Nick Robertson  
6227 5<sup>th</sup> AVE NW  
Seattle, WA 98107.  
RE: 2009-003-SUB1- ZETTEL RESIDENCE  
6415 SE 24<sup>TH</sup> ST MERCER ISLAND 98040

Please see correction responses for **CORRECTION NOTICE #1- ORDINANCE/STRUCTURAL**

PROPOSED EXTERIOR
ELEVATIONS

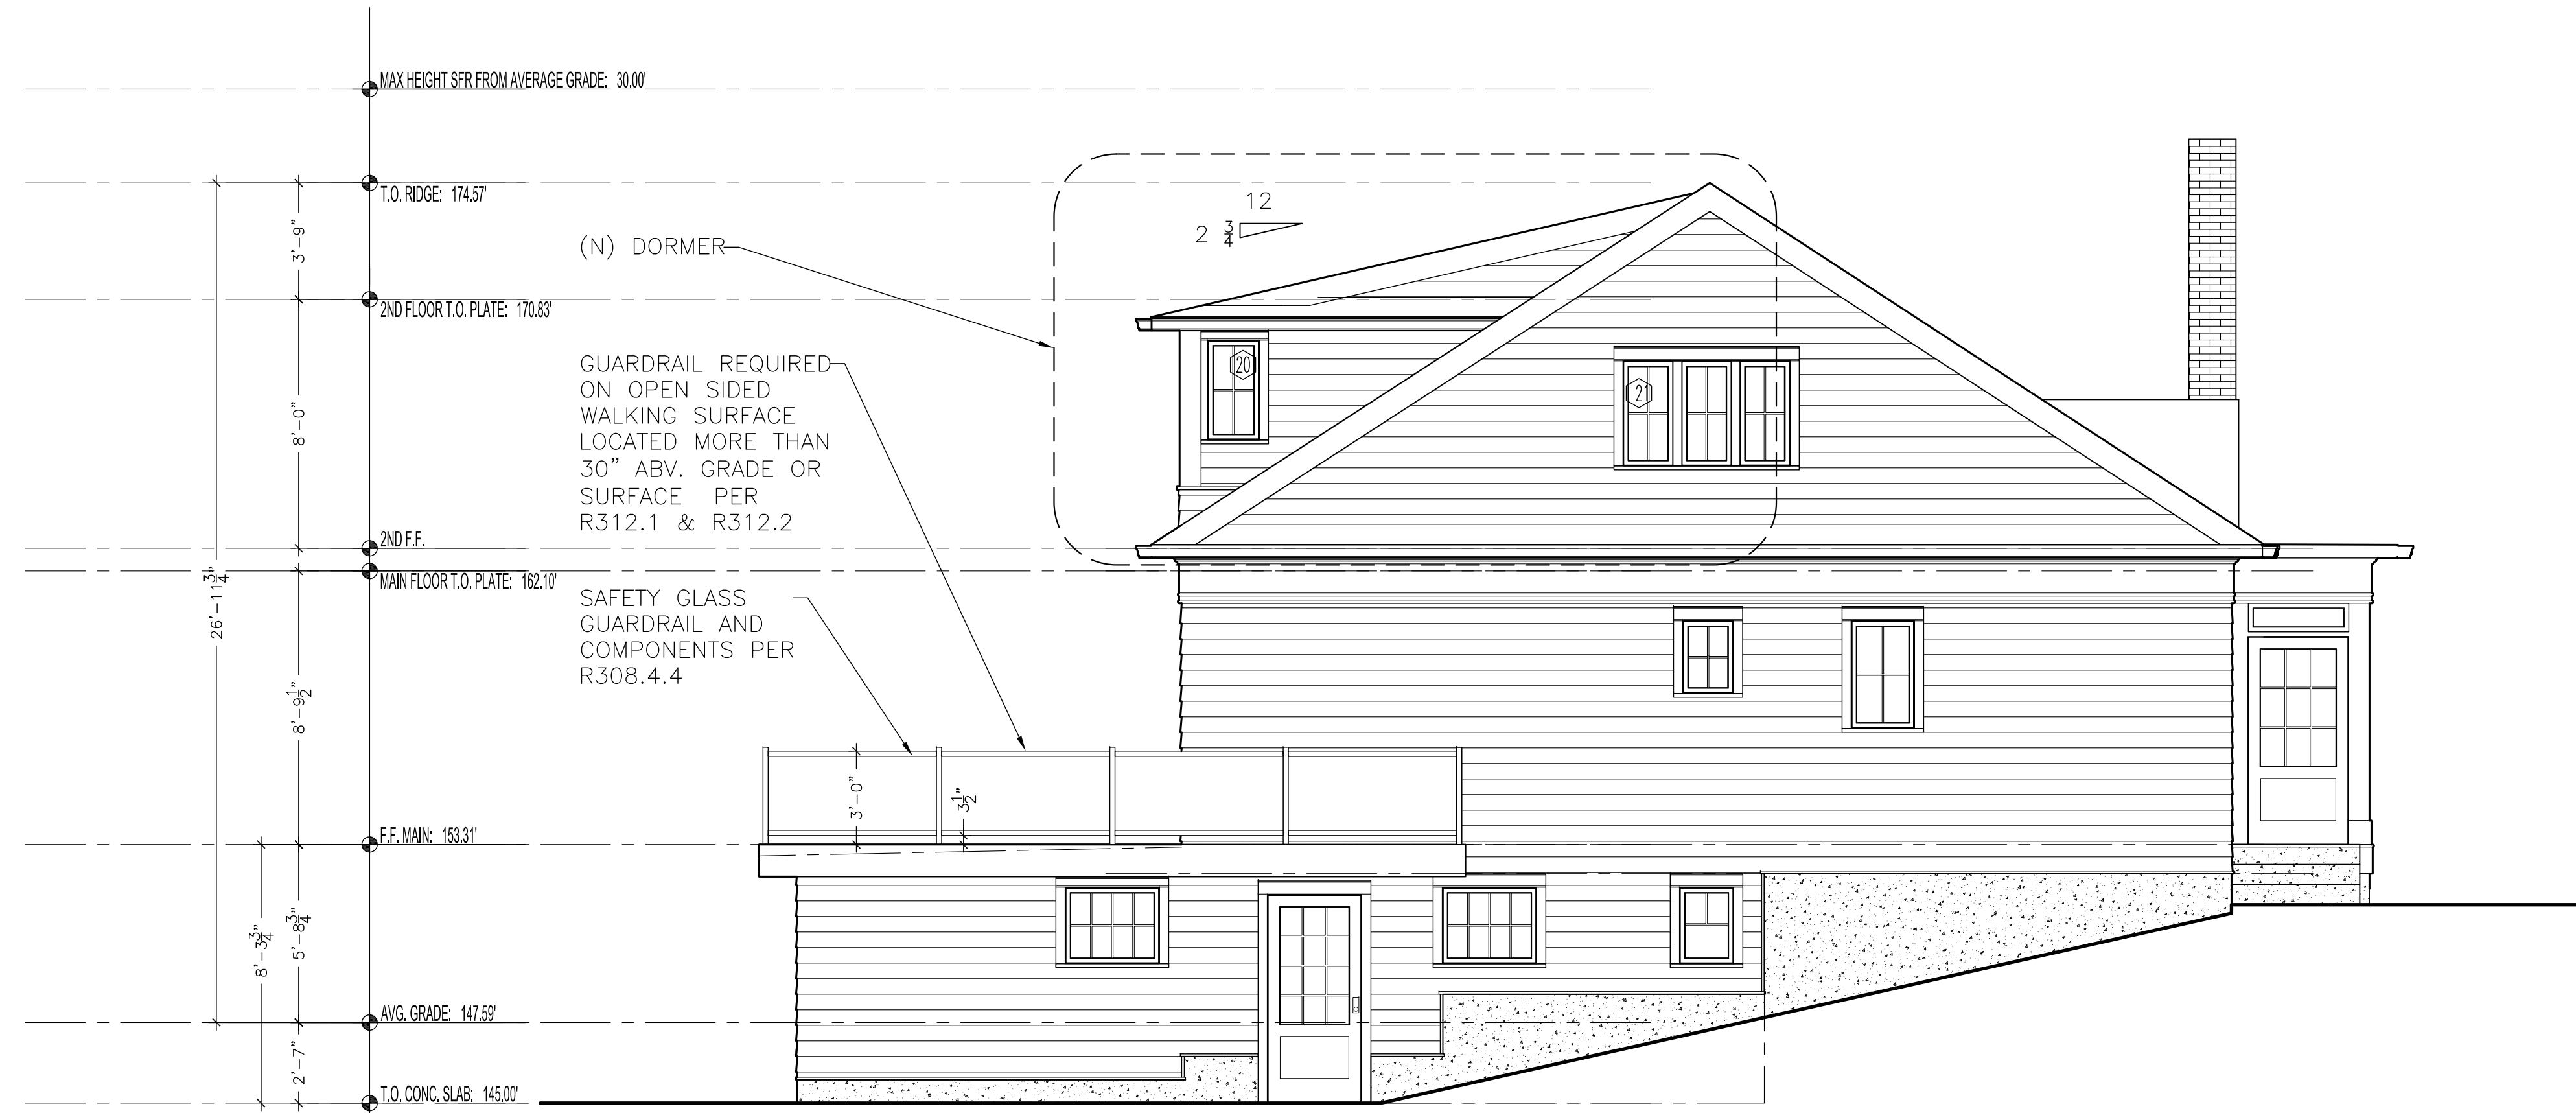
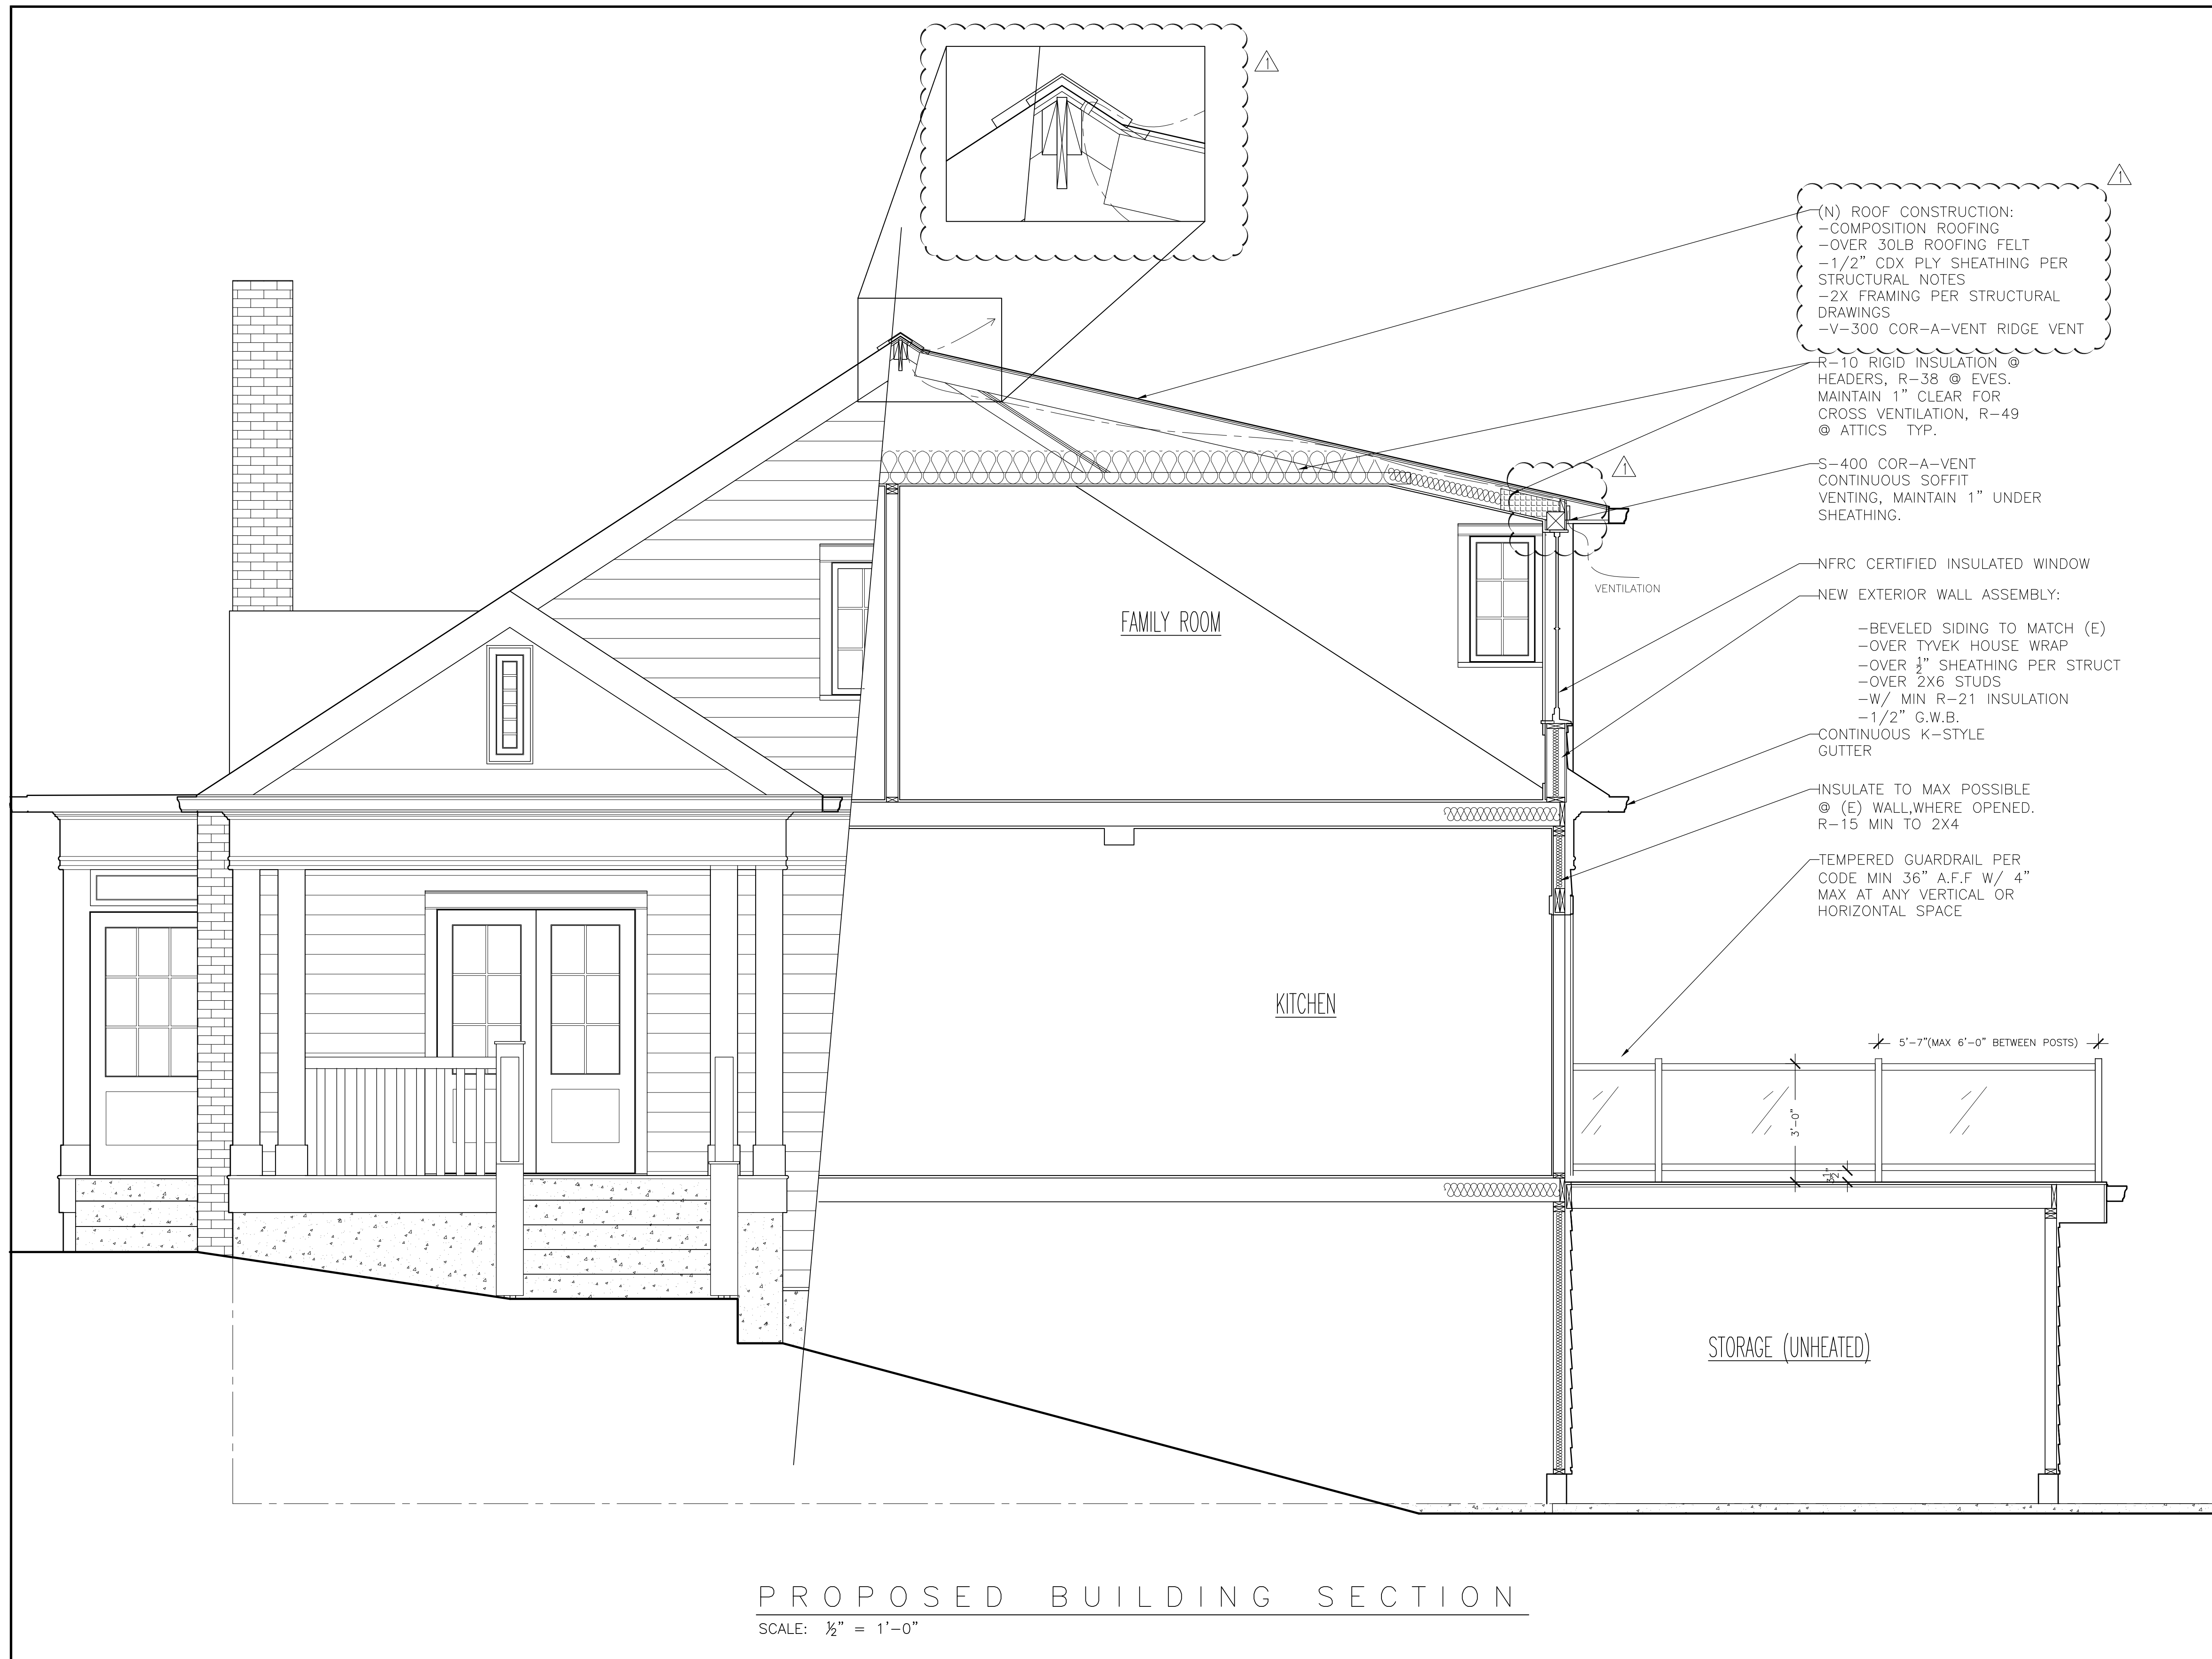
Author: Planning Review (andrew.leon@mercergov.org) Subject: Comment Date: 10/29/2020 12:35:39 PM -07'00'  
Based on the provided scale, the height of this facade is over 25 feet. MICC 19.02.020(C)(1)(c)(iii)((b)) states that a 10-foot side yard setback is required adjacent to wall facades greater than 25 feet in height. Please verify the height of the wall facade on the west side of the house and modify the setbacks on the site plan if necessary.

Author: NICK ROBERTSON (NICK@STUDIOPIANONOBILE.COM) Subject: Date: 12/11/2020 5:08:55 PM  
Sticky Note: dimension of west facade has been added to sheet A9 noting 24'-10"

A10

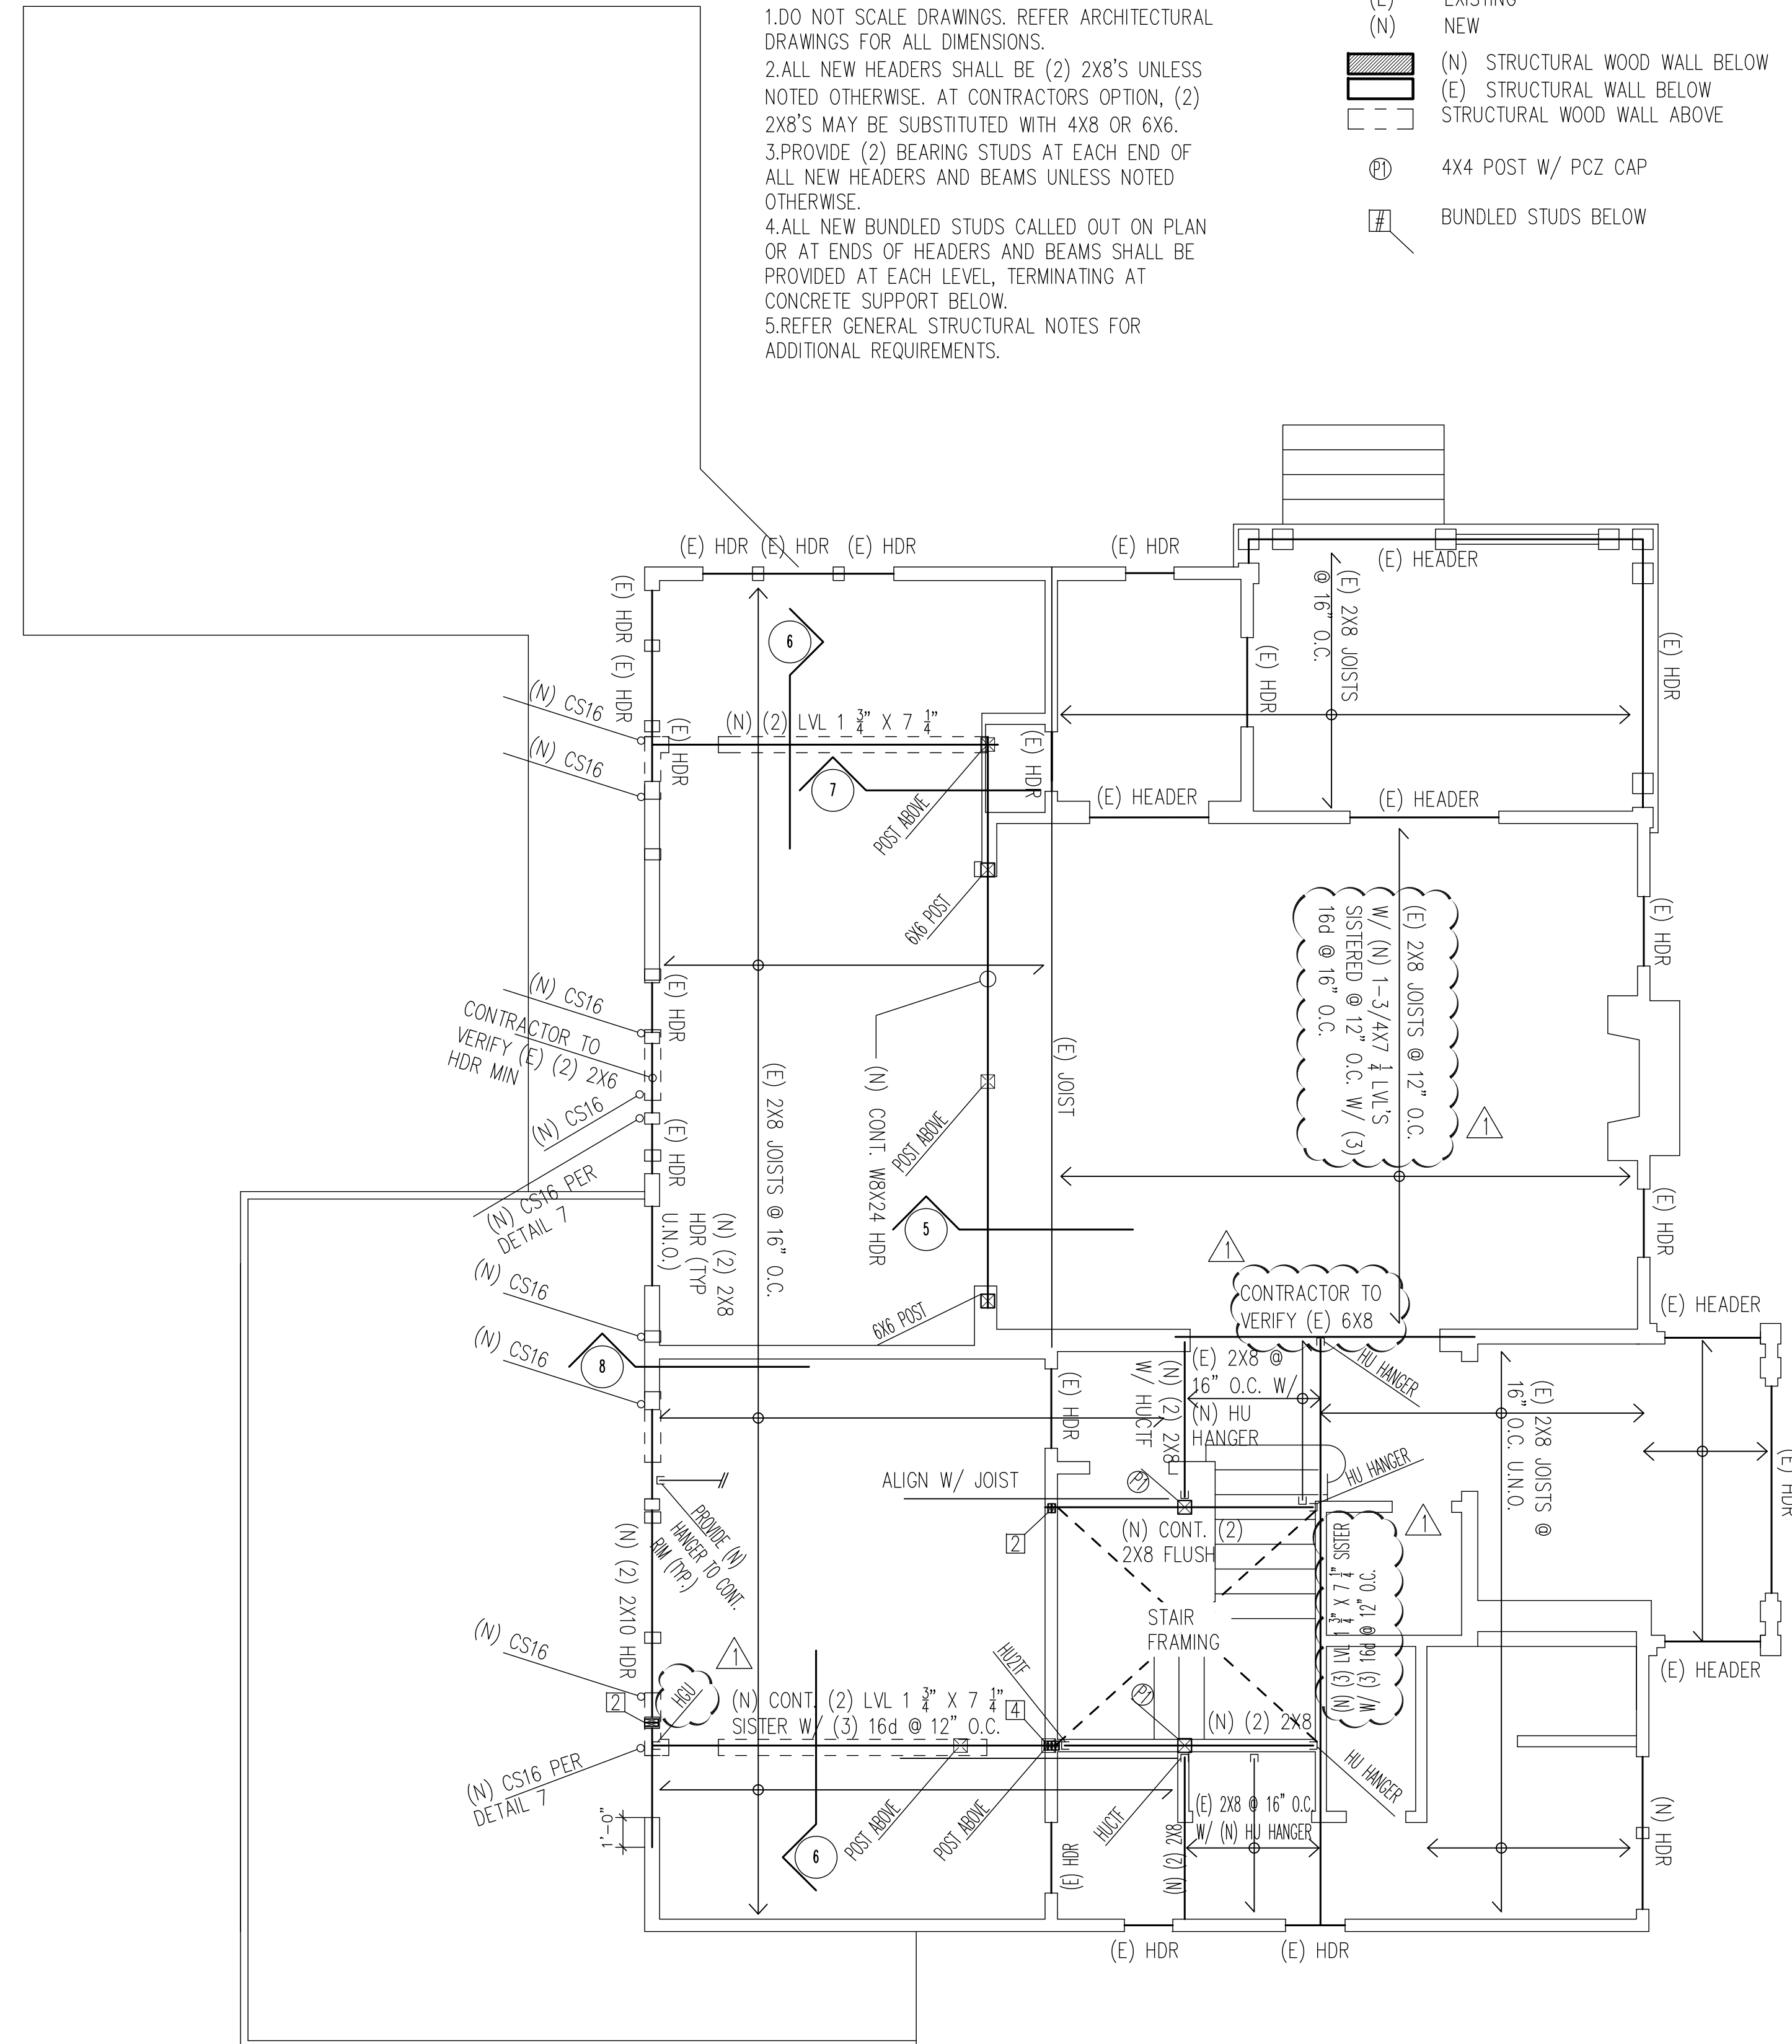
Please coordinate header size with architectural drawings. See sheet A10.

Show how ventilation is provided at roof ridge.

Author: NICK ROBERTSON (NICK@STUDIOPIANONOBILE.COM) Subject: Date: 12/18/2020 5:53:51 AM  
Sticky Note header size is correct, sheet A10 building section has been updated

Author: NICK ROBERTSON (NICK@STUDIOPIANONOBILE.COM) Subject: Date: 12/17/2020 3:26:27  
Sticky Note: See updated building section on sheet A10 showing ridge vent
